CITY OF PORTLAND

BUILDING PERMIT

Job ID: 2011-10-2354-ALTR

has permission to Second Floor Addition (Single Family Residence).

2nd floor
Bedroom

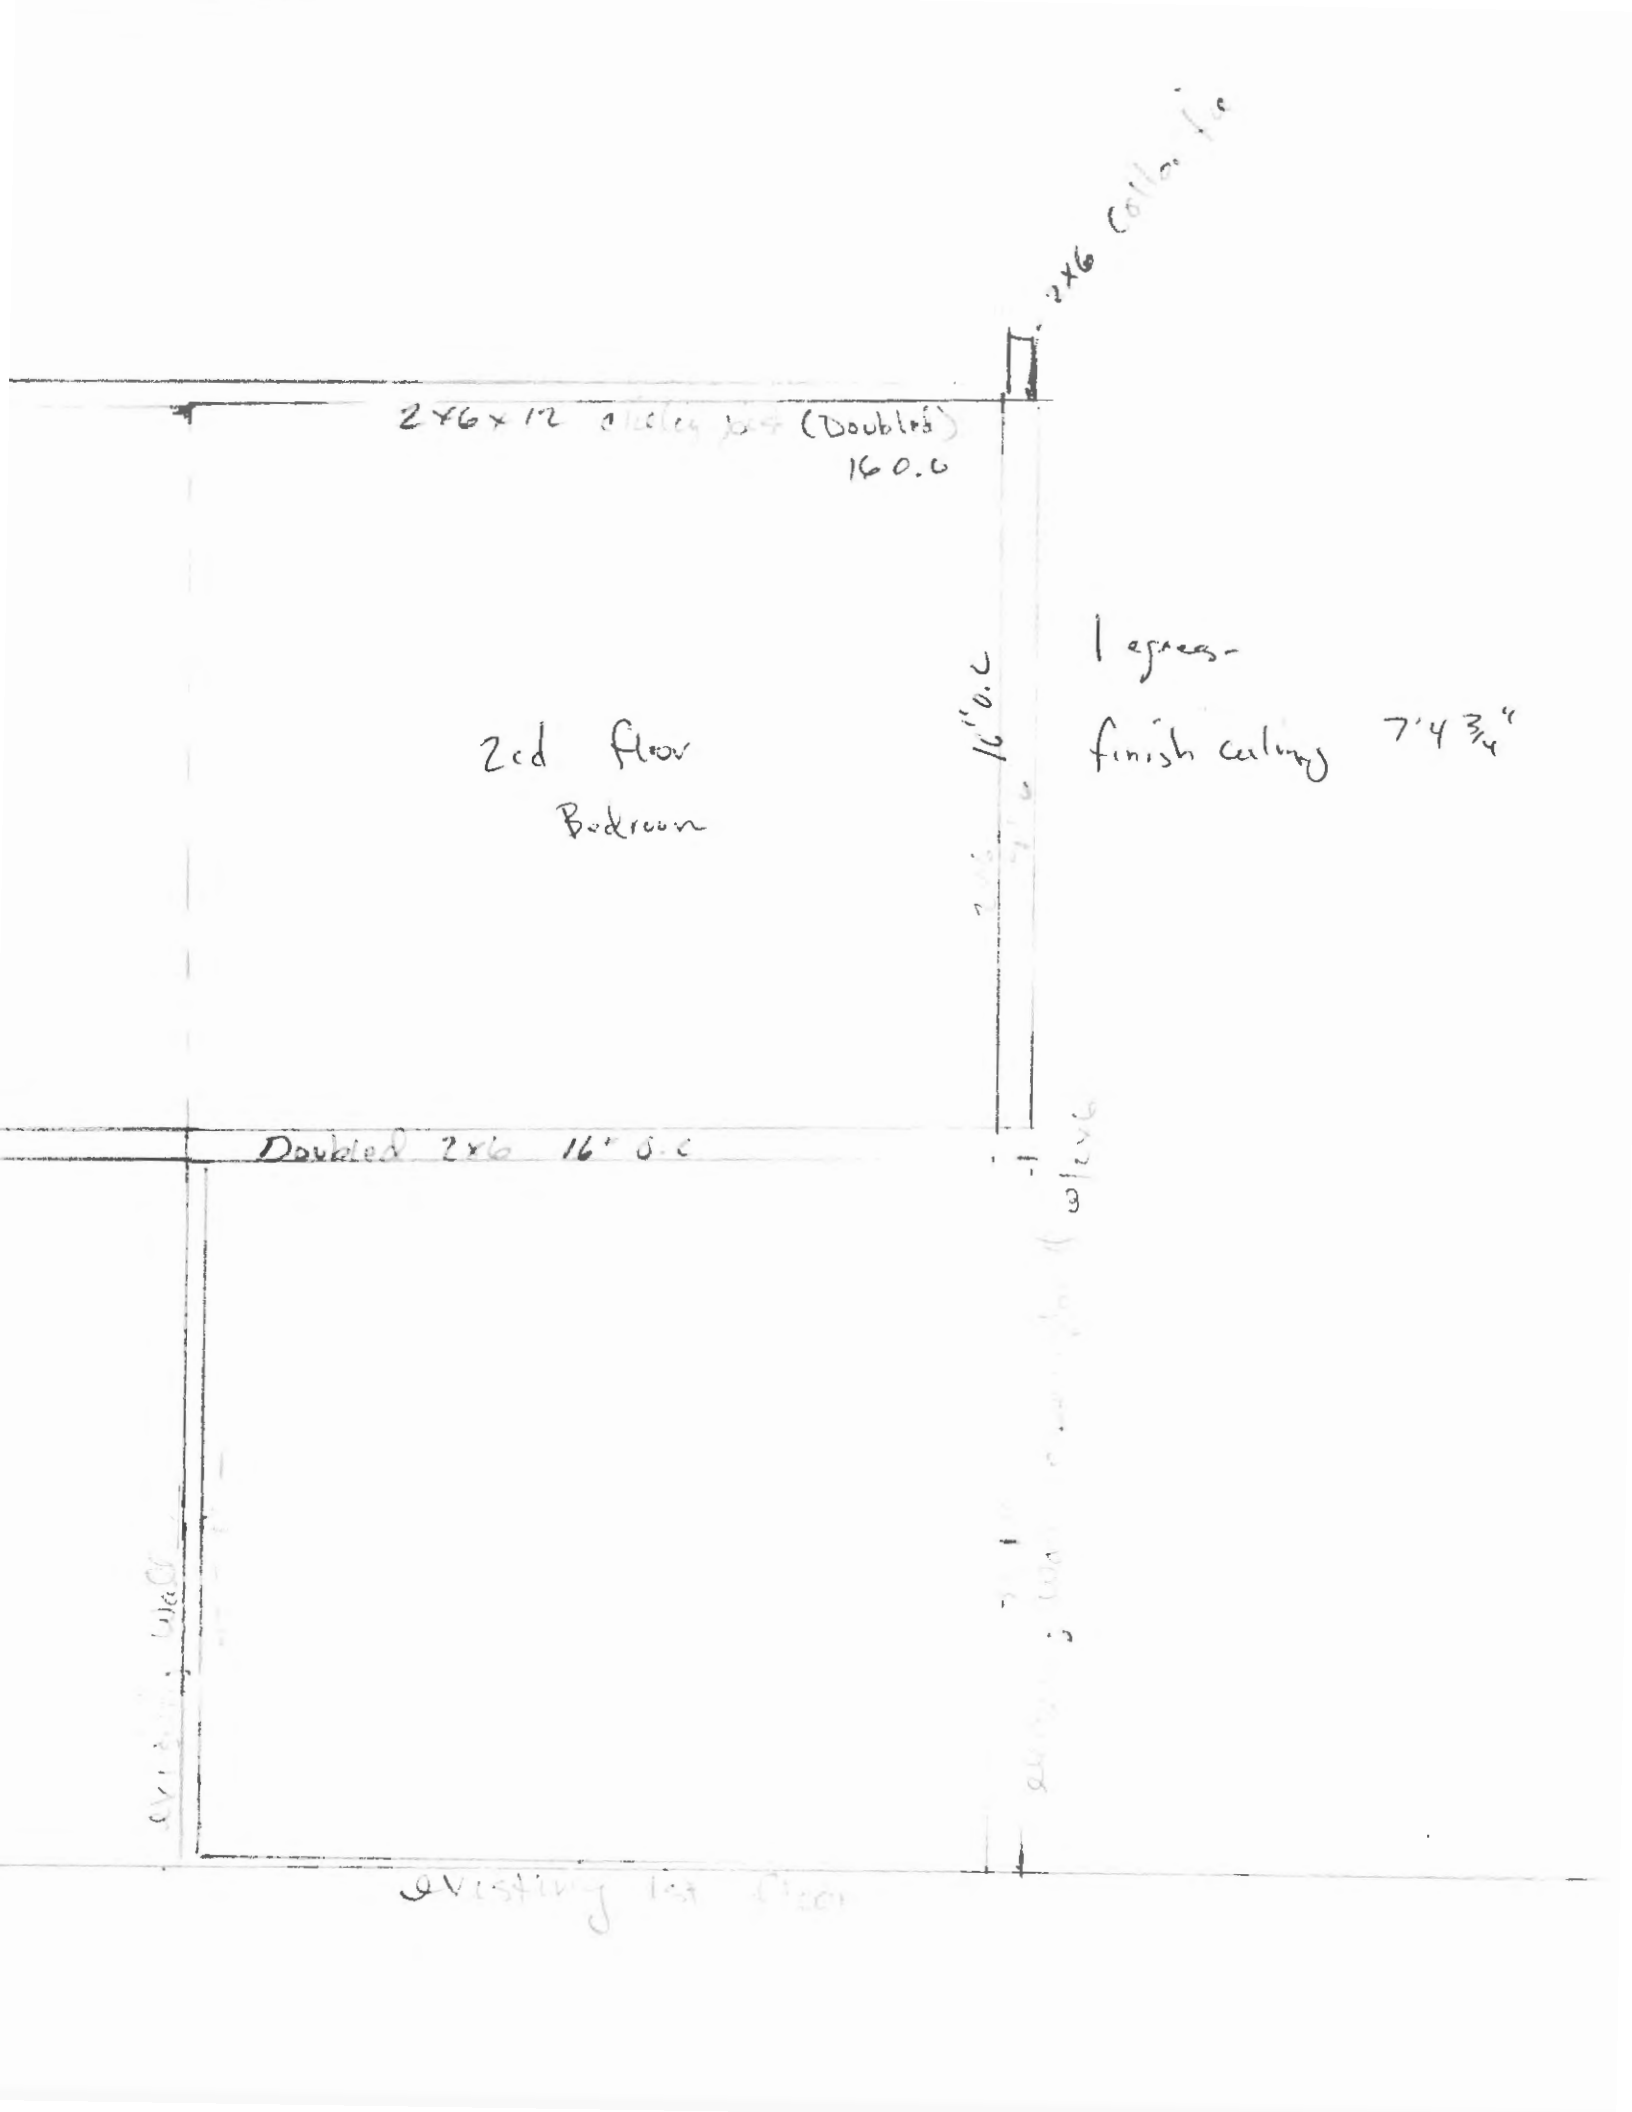
9. R305.1 Minimum height. Habitable space, hallways, bathrooms, toilet rooms, laundry rooms and portions of basements containing these spaces shall have a ceiling height of not less than 7 feet.

- a. 1. For rooms with sloped ceilings, at least 50 percent of the required floor area of the room must have a ceiling height of at least 7 feet and no portion of the required floor area may have a ceiling height of less than 5 feet.

- 10. Girder spans and Header spans for exterior bearing walls shall comply with TABLE R502.5(1). The Contractor agreed that this shall include the existing header(s) beneath the proposed addition area and the second floor 8 foot 6 inch span, modification may be required.**

← 33' →
ROOF PLAN WITH SECOND STORY EXTENSION
WEST ↓ 1" = 5' DE 12/1/11

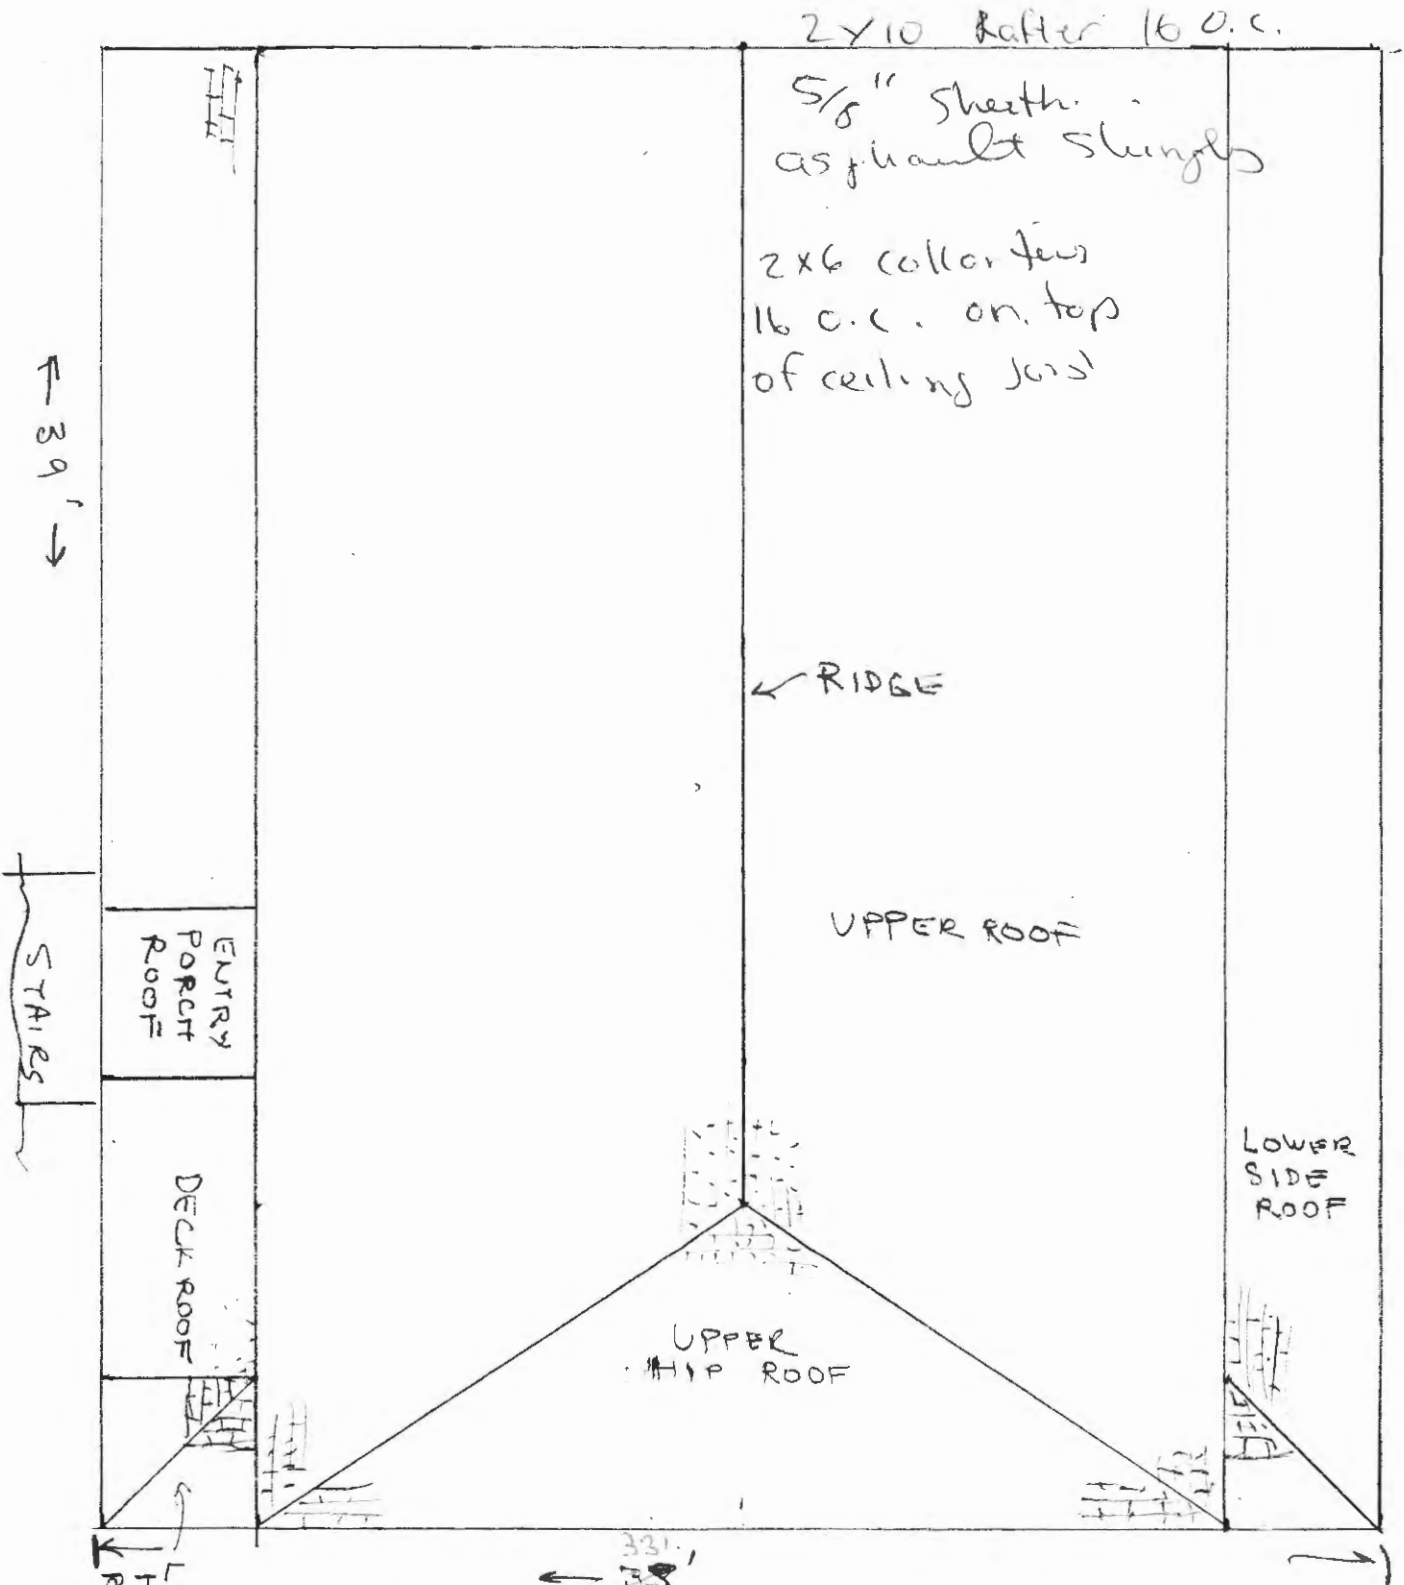
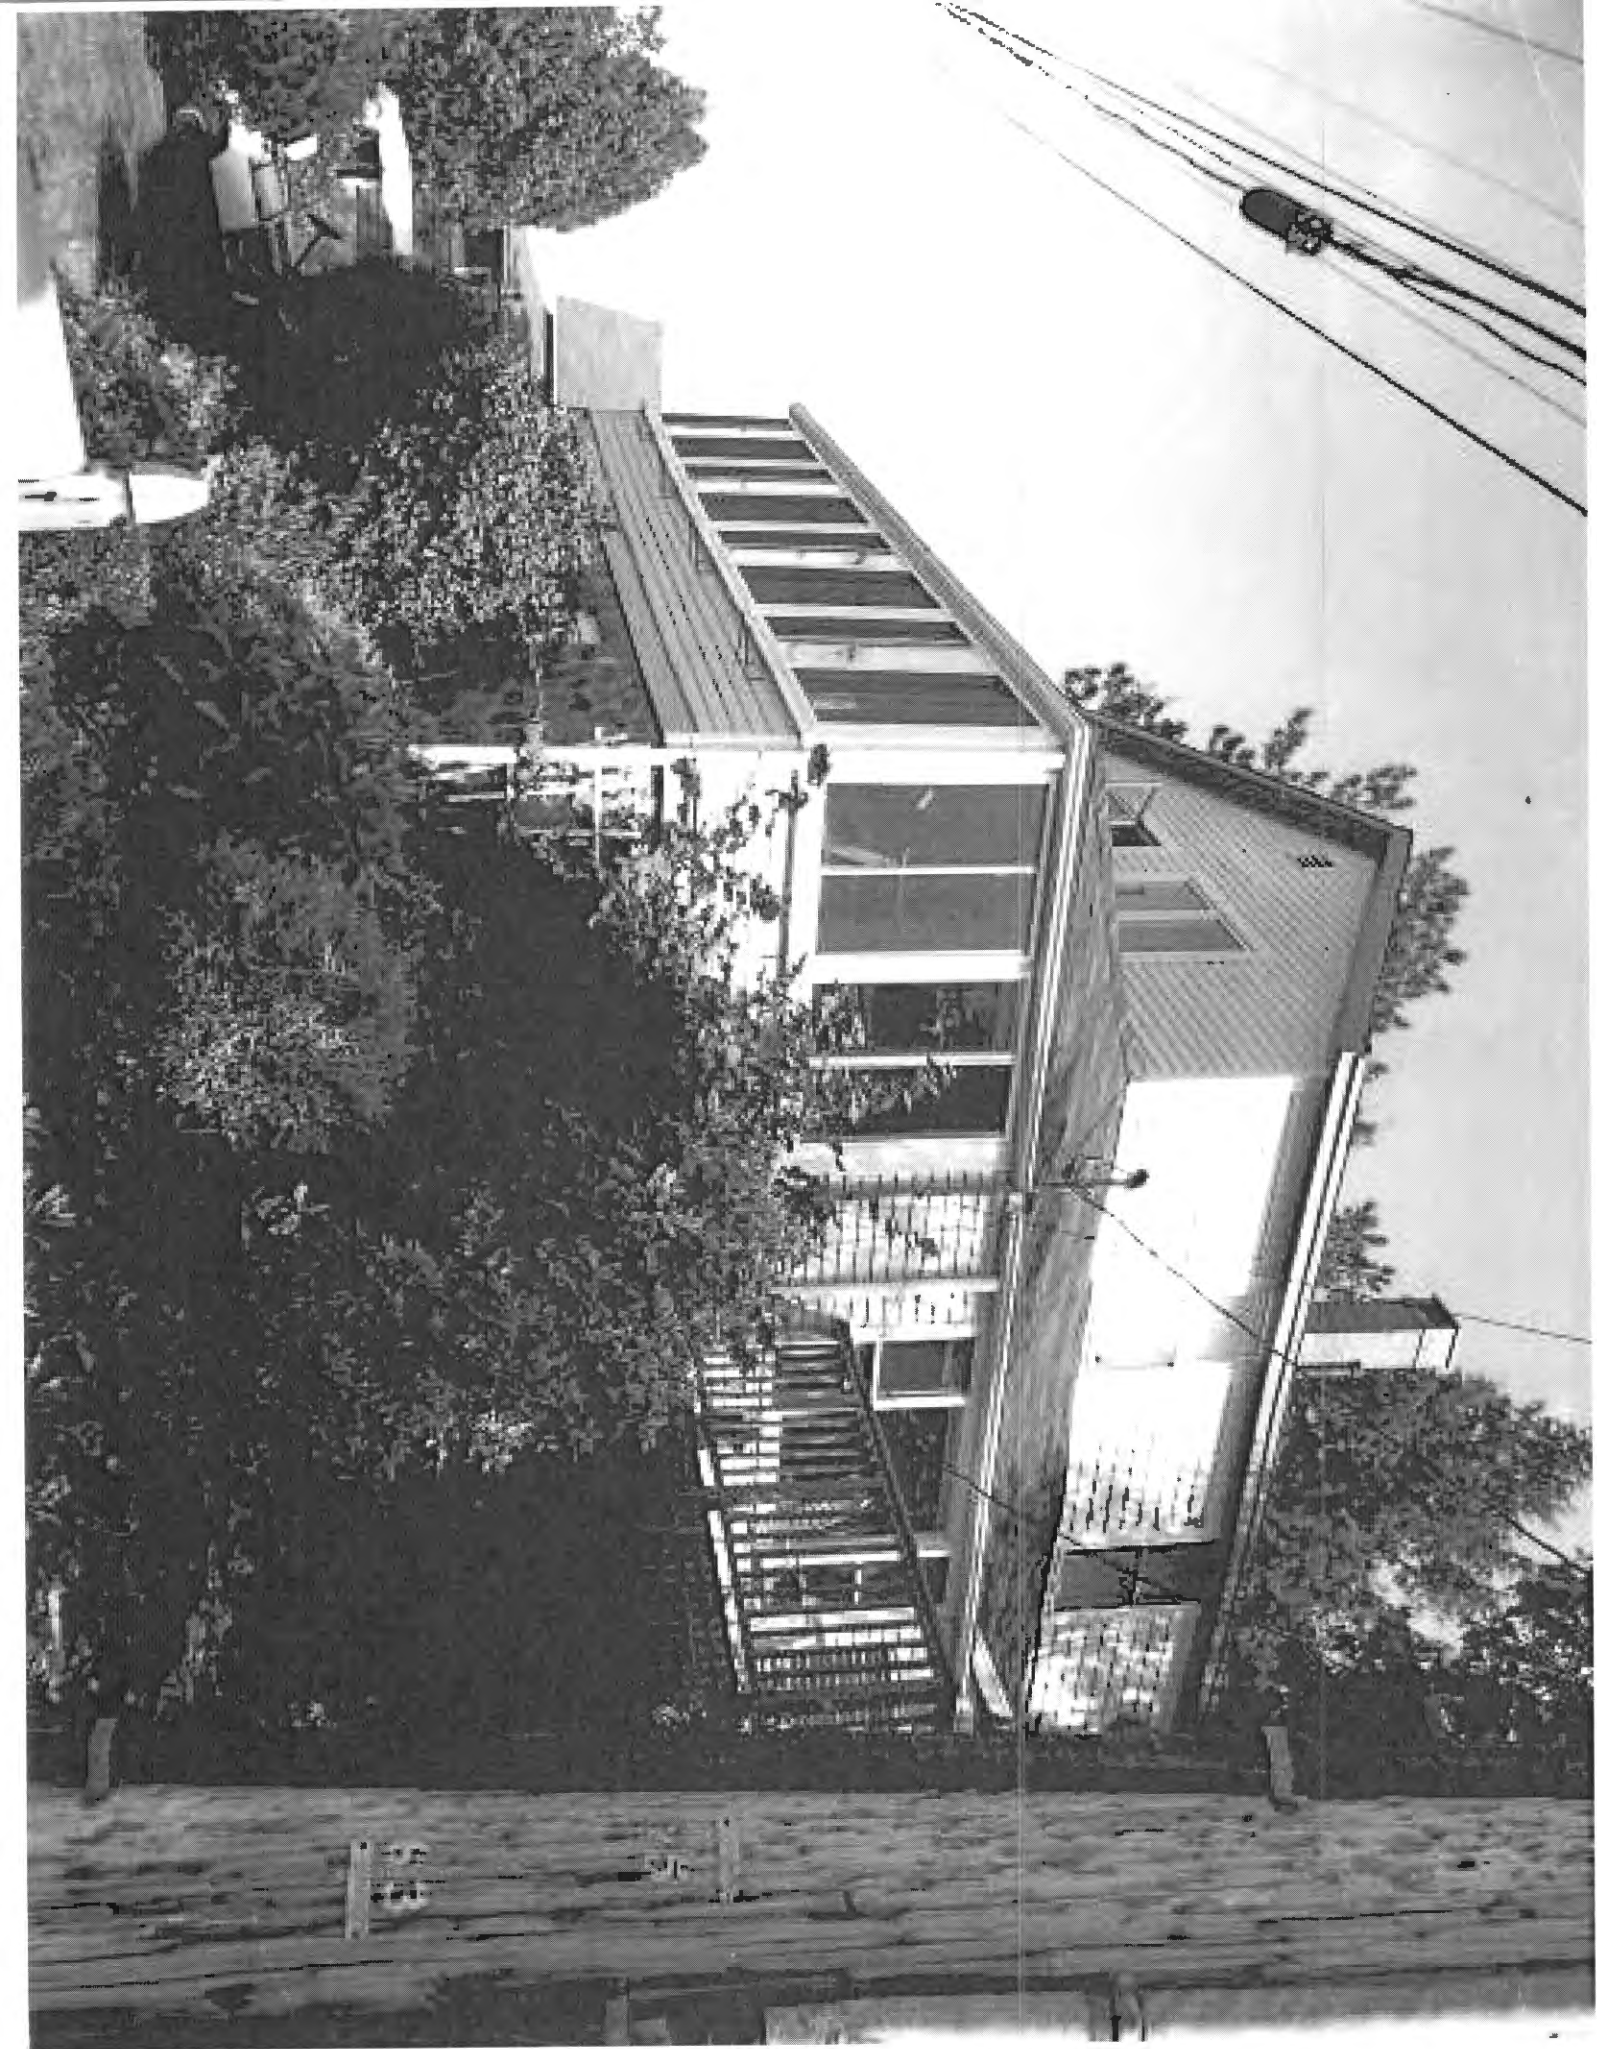
2. Roof Rafter framing and Connection shall comply with Section R802.3 & R802.3.1 of MUBEC.
3. A code compliant emergency escape shall be provided in the bedroom. Window sills in locations more than 72 inches from finished grade shall be a minimum of 24 inches (no higher than 44 inches) above the finished floor of the room, or in compliance with Section R612.4.2 Operation for emergency escape.

6. R502.6 Bearing. The ends of each joist, beam or girder shall have not less than 1.5 inches of bearing on wood or metal and not less than 3 inches on masonry or concrete except where supported on a 1-inch-by-4-inch ribbon strip and nailed to the adjacent stud or by the use of approved joist hangers. This shall include the Engineered Structural Ridge Beam.
